# SSD 16\_7539: DARLINGTON TERRACES MIXED USE DEVELOPMENT

## THE UNIVERSITY OF SYDNEY, DARLINGTON CAMPUS

### AMENDMENT TO THE PROPOSAL

### RESPONSE TO SUBMISSIONS

10 01 JUNE 3PM  
1:200

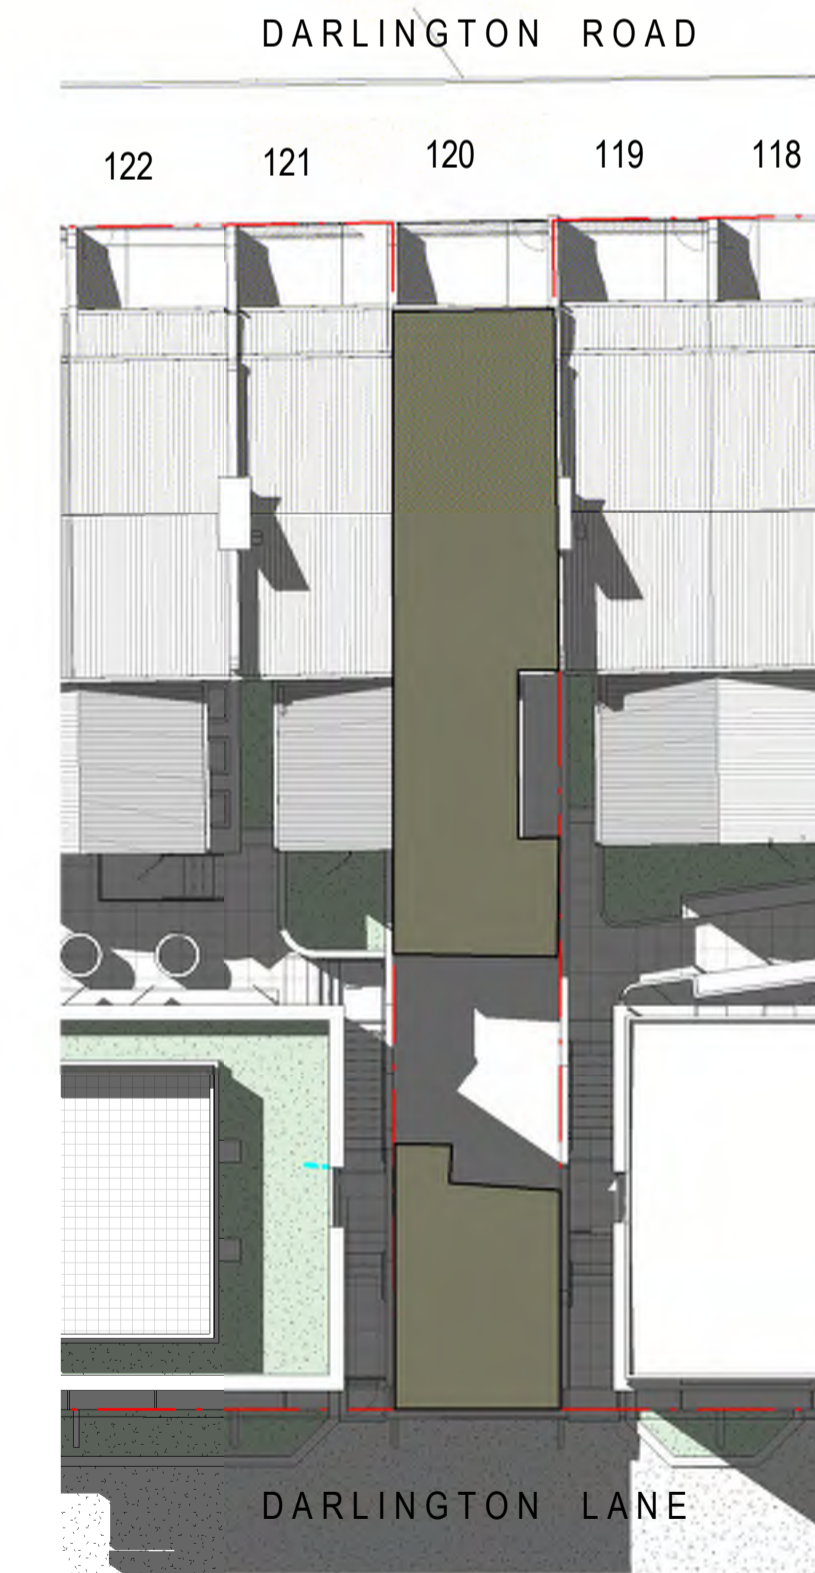
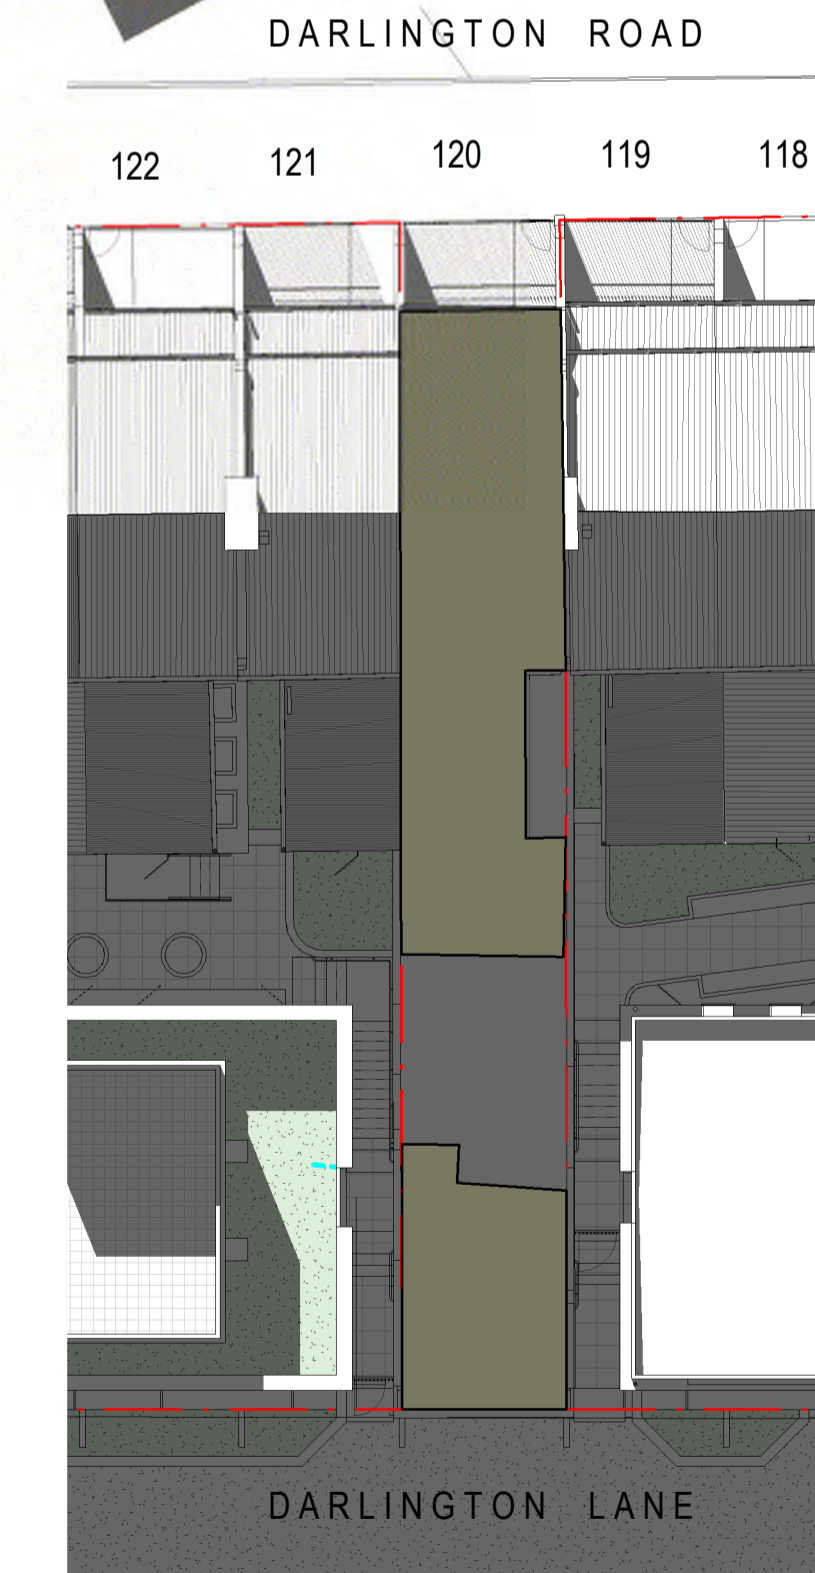
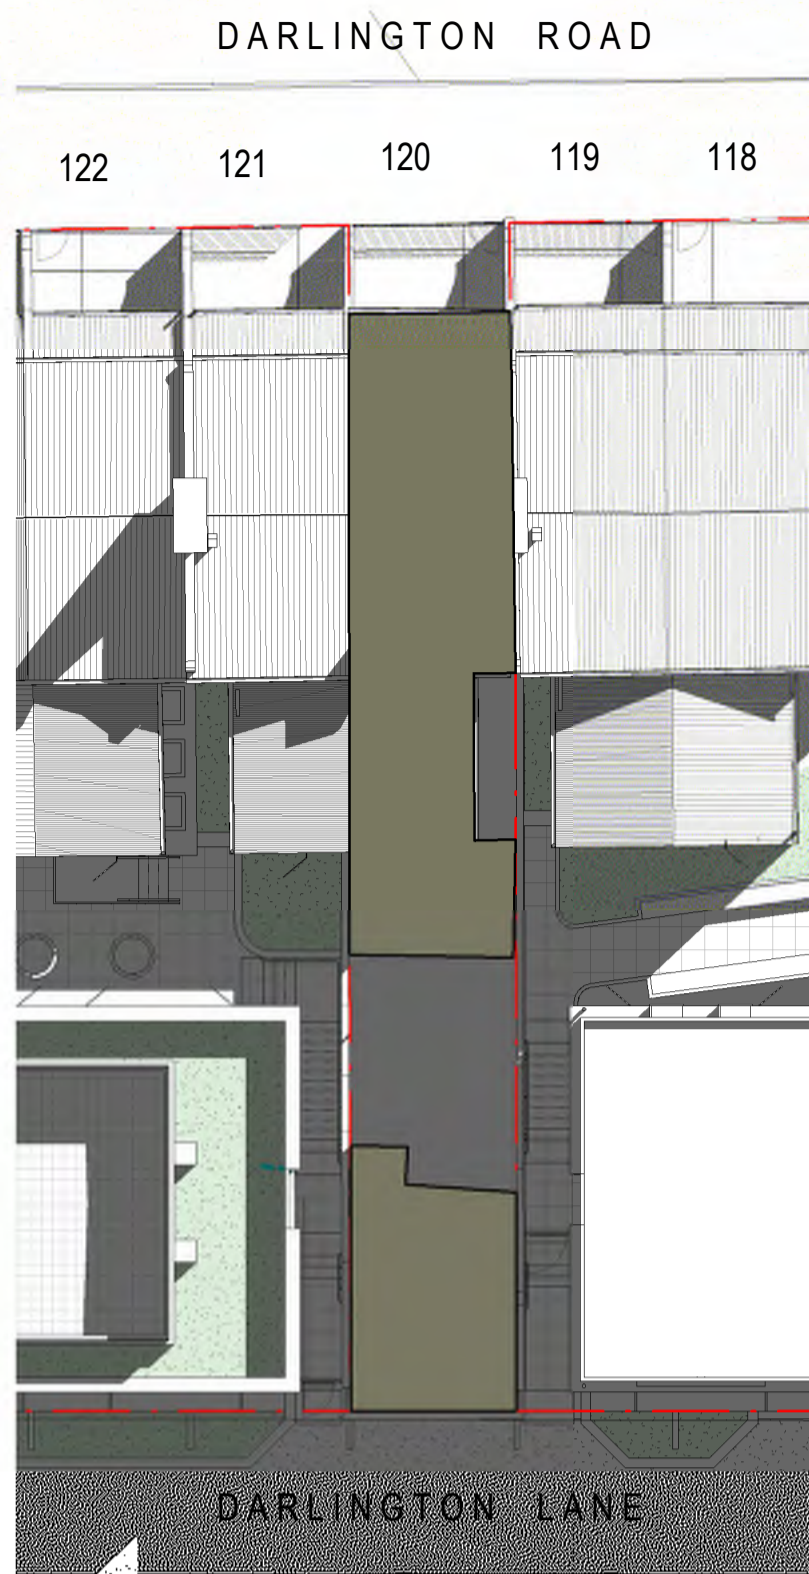
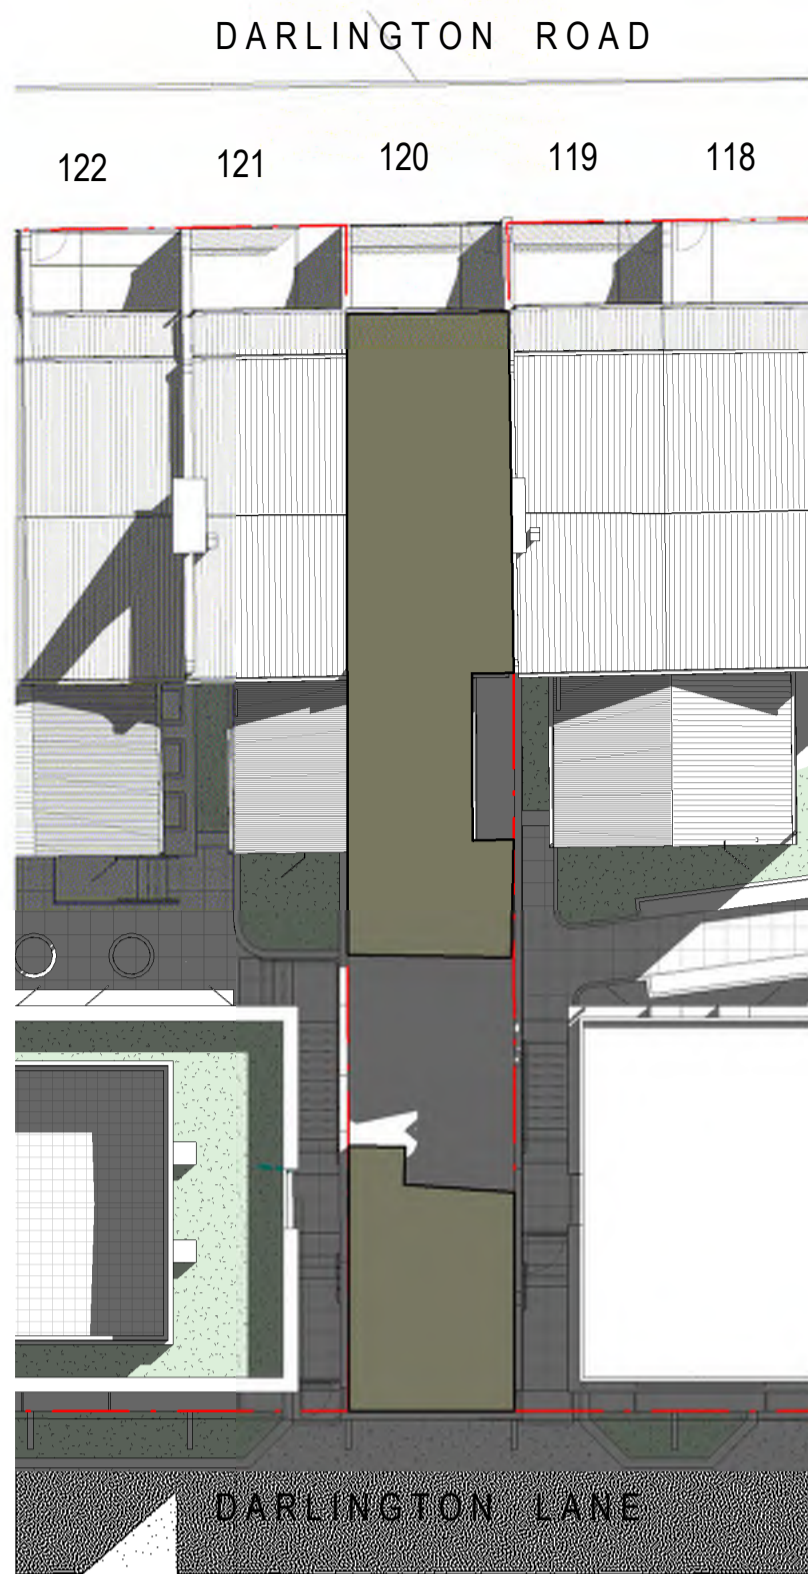
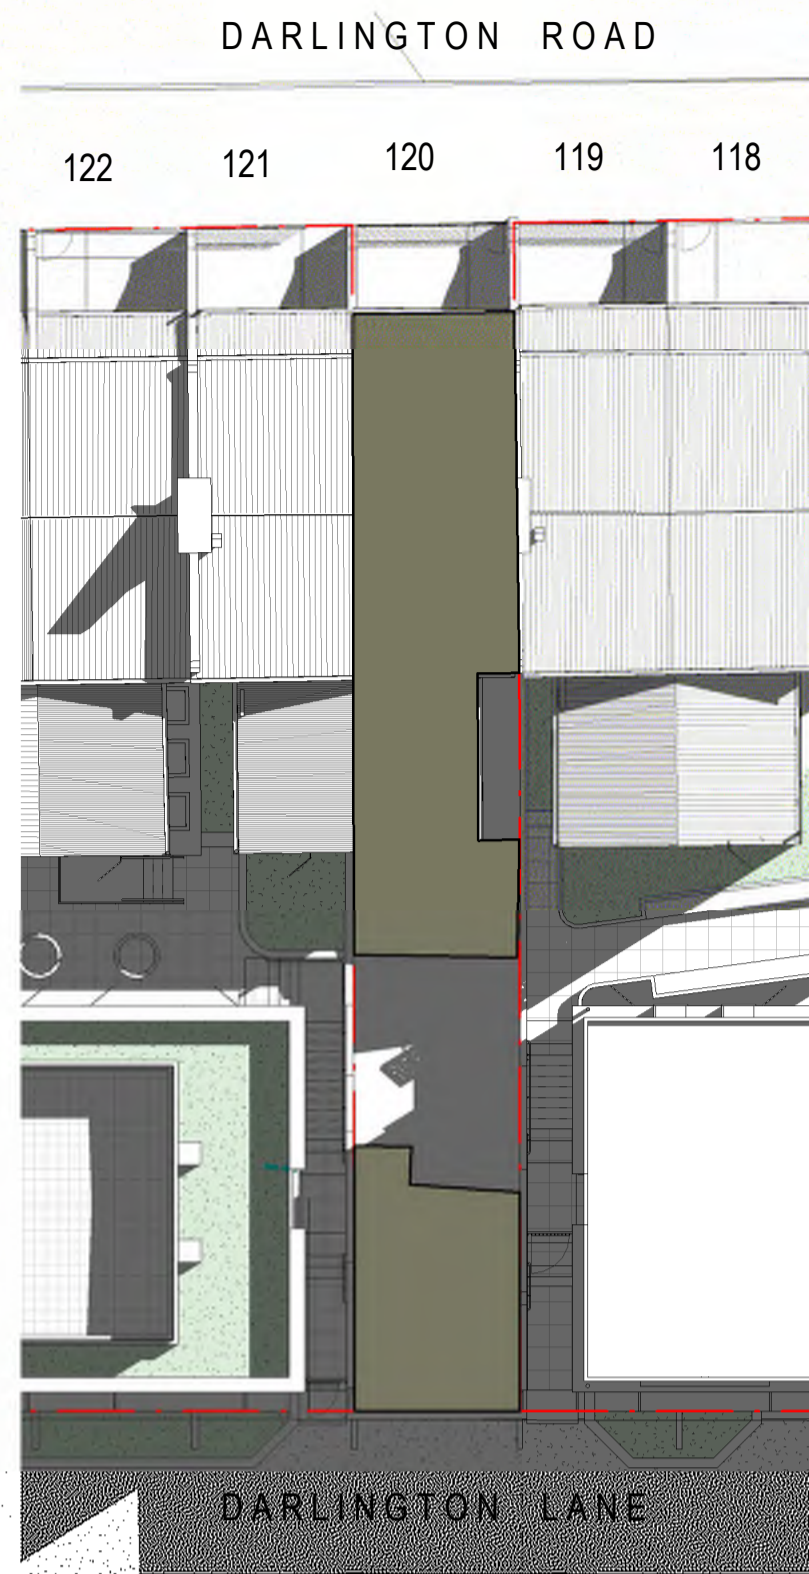
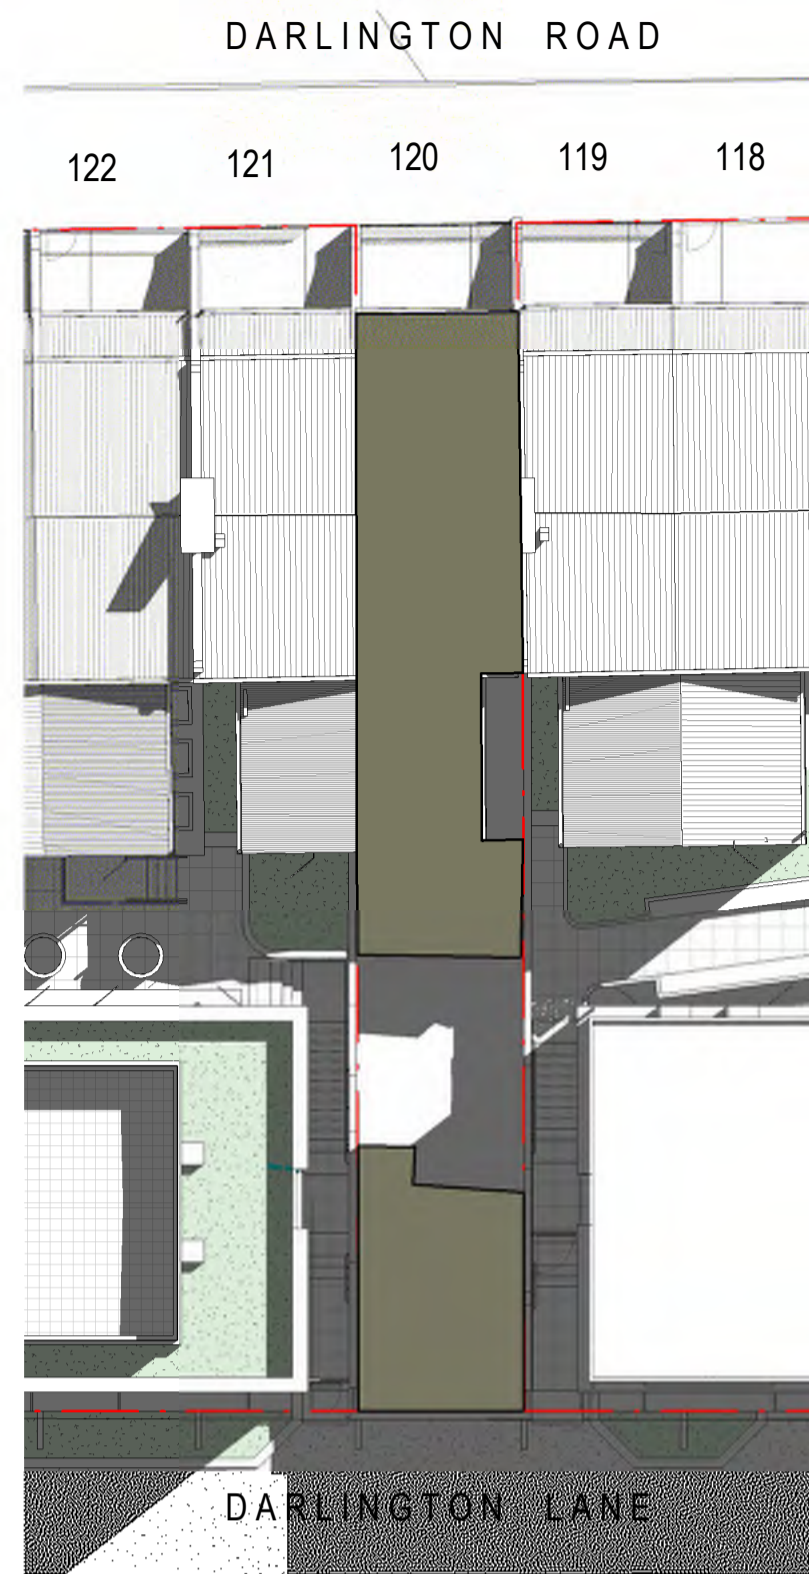
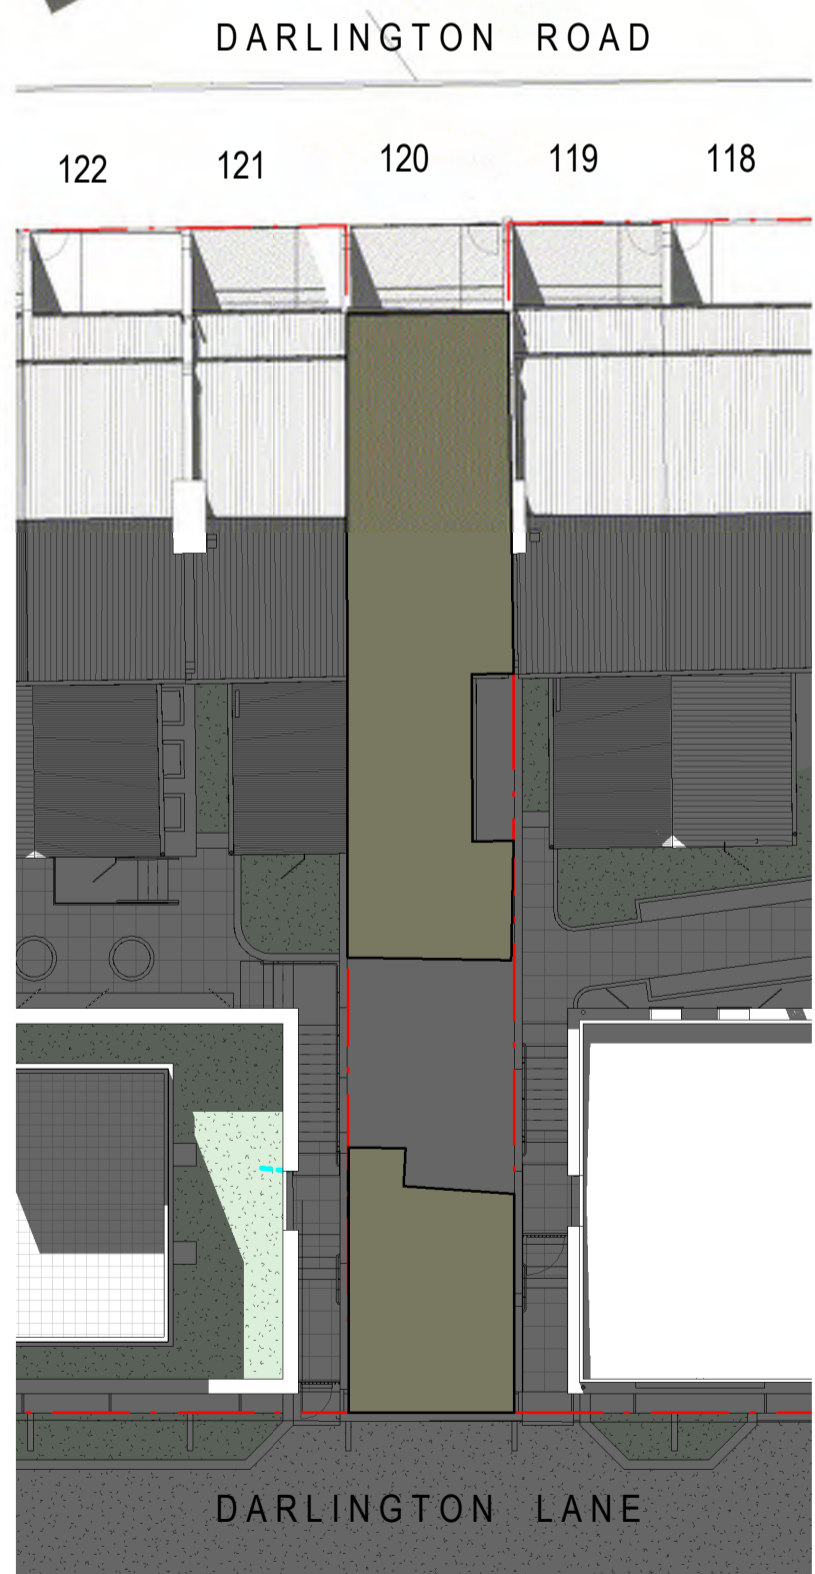
<p><b>Residential Amenity</b></p> <p>3. The overshadowing analysis must illustrate that adequate solar access has been maintained to the adjoining private residential properties and additional overshadowing from the proposal does not result affected properties retaining less than a minimum two hours of solar access to 50 per cent of the private open space areas between 9 am and 3 pm on 21 June. Additional shadow diagrams illustrating overshadowing at hourly intervals (at a minimum) must be provided to clearly demonstrate impacts on open space areas of the private residential properties affected by the proposal.</p>	<p><b>Agreed:</b> The amended Shadow Analysis by project architects AJ+C are addressed in the package of Architectural Plans (<b>Appendix A-3</b>). The two privately owned Terraces located in between the proposed new buildings are No’s 120 and 97 Darlington Road and the Shadow impacts to the rear yards of these Terraces are addressed at <b>Appendix A-4</b>.</p> <p>The AJ+C Shadow Analysis confirms that:</p> <ul style="list-style-type: none"> <li>• No. 120 Darlington Road currently receives less than 2 hours sunlight to 50% of open space, and will not receive any additional shadows to the rear yard of the property because of the proposed development; and</li> <li>• No. 97 Darlington Road currently receives less than 2 hours sunlight to 50% of open space. The design of new Building Block D, immediately to the east of and adjoining 97 Darlington Road, has been modified by including a splayed treatment at its north-western corner, in order to avoid any additional overshadowing and thereby ensure that current levels of solar access to the rear yard of (private) 97 Darlington Street are maintained as existing.</li> </ul>

SSD 16_7539 – DARLINGTON TERRACES MIXED USE DEVELOPMENT	
DPIE KEY ISSUE	UNIVERSITY PROJECT RESPONSE
	<p>The AJ+C shadow analysis at <b>Appendix A</b> also includes an hour-by-hour birds eye view of solar access which demonstrates that compliant levels of solar access will be provided to the north facing elevations of the new Darlington Terraces. Solar access to the street front facades of the original Darlington Terraces fronting Darlington Road will remain unaltered.</p>
<p>4. Further <b>Shadow Impacts</b> upon (private) 120 Darlington Road:</p> <ul style="list-style-type: none"> <li>• DPIE acknowledges no mid-winter shadow impacts or any solar reception.</li> <li>• DPIE request an assessment of solar impacts at other times of the year to ascertain what solar access 120 Darlington will receive for min 8sq.m. for period of 2 hours.</li> <li>• If the above-mentioned solar access cannot be received, then USYD to consider built form amendment.</li> <li>• Seek commentary on built form compliance with CIP for solar access.</li> </ul>	<p><b>Agreed:</b> Additional Solar Access Plans (Dwgs DA3910 - DA3913) have been prepared by AJ+C and are found at <b>Appendix A-3</b> (overall mid-winter analysis) and <b>Appendix A-4</b> (for 120 Darlington Road).</p> <p>An analysis of the overshadowing impact of the SSD proposal to the privately owned property at 120 Darlington Road has been conducted on the 1<sup>st</sup> and 15<sup>th</sup> day of each month, and concludes:</p> <ul style="list-style-type: none"> <li>• From 01 January – 01 May (4 months) No.120 Darlington Road will receive 2 hours and above of sunlight to at least 8m<sup>2</sup> of its rear private open space (southern aspect). The property will <b>also</b> receive at least 2 hours and above sunlight to at least 8m<sup>2</sup> of its front private open space facing Darlington Road (northern aspect).</li> <li>• From 01 May – 01 September (4 months) No.120 Darlington Road will receive 2 hours and above of sunlight to at least 8m<sup>2</sup> of its front private open space facing Darlington Road (northern aspect).</li> <li>• From 01 September – 01 January (4 months) No.120 Darlington Road will receive 2 hours and above of sunlight to at least 8m<sup>2</sup> of its rear private open space (southern aspect). The property will <b>also</b> receive at least 2 hours and above of sunlight to at least 8m<sup>2</sup> of its front private open space facing Darlington Road (northern aspect).</li> </ul> <p>✓ In summary, N°.120 Darlington Road will receive at least 2 hours of sun to at least 8m<sup>2</sup> of private open space all year round and will therefore more than satisfy the objectives of <i>Sydney DCP 2012</i> clause 4.1.3.1 <i>Solar Access</i>.</p> <p>✓ Notwithstanding the solar access compliance described above, the University confirms that the built form of the rear Darlington Terraces additions complies with the maximum building envelopes approved by the CIP – SSD 13_61123 (refer to AJ+C elevations for plans to illustrate building envelope compliance at <b>Appendix A-2</b>).</p>
